From: [Kelly Bacon \(CD\)](#)
To: [Downes, Scott G \(DFW\)](#)
Cc: [Torrey, Elizabeth M \(DFW\)](#)
Subject: RE: SE-22-00005 Haase - Notice of Application
Date: Tuesday, March 15, 2022 9:30:25 AM
Attachments: [SE-22-00005 Haase SEPA Site plan.pdf](#)

Subject: SE-22-00005 Haase - Notice of Application

SITE PLAN

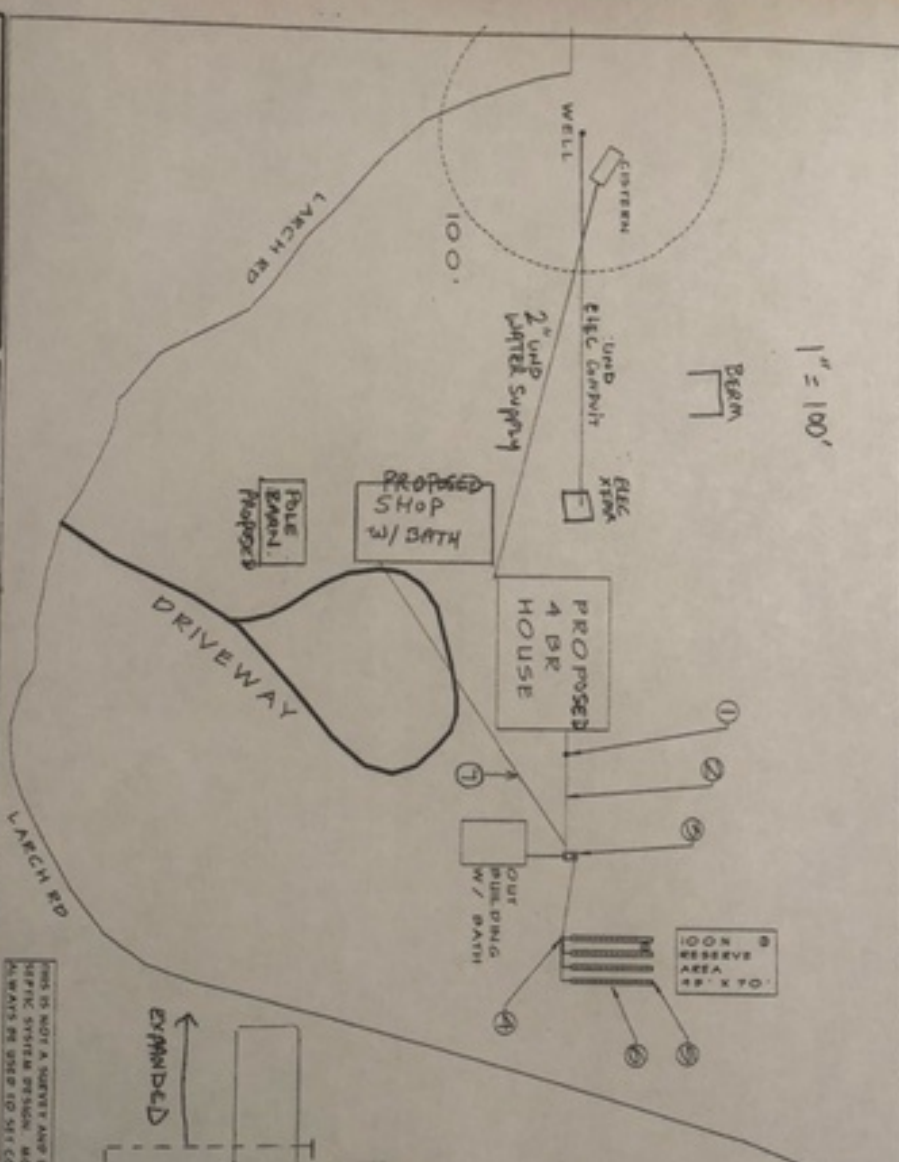
To follow up on this, there are streams on both the western and eastern ends of this property. Their site plan would need to be set back from these streams per the CAO requirements. The stream on the western edge is a Ns stream, non-fish bearing seasonal stream and on the eastern end is a disconnected portion of the North Fork Teanaway river and associated shoreline area.
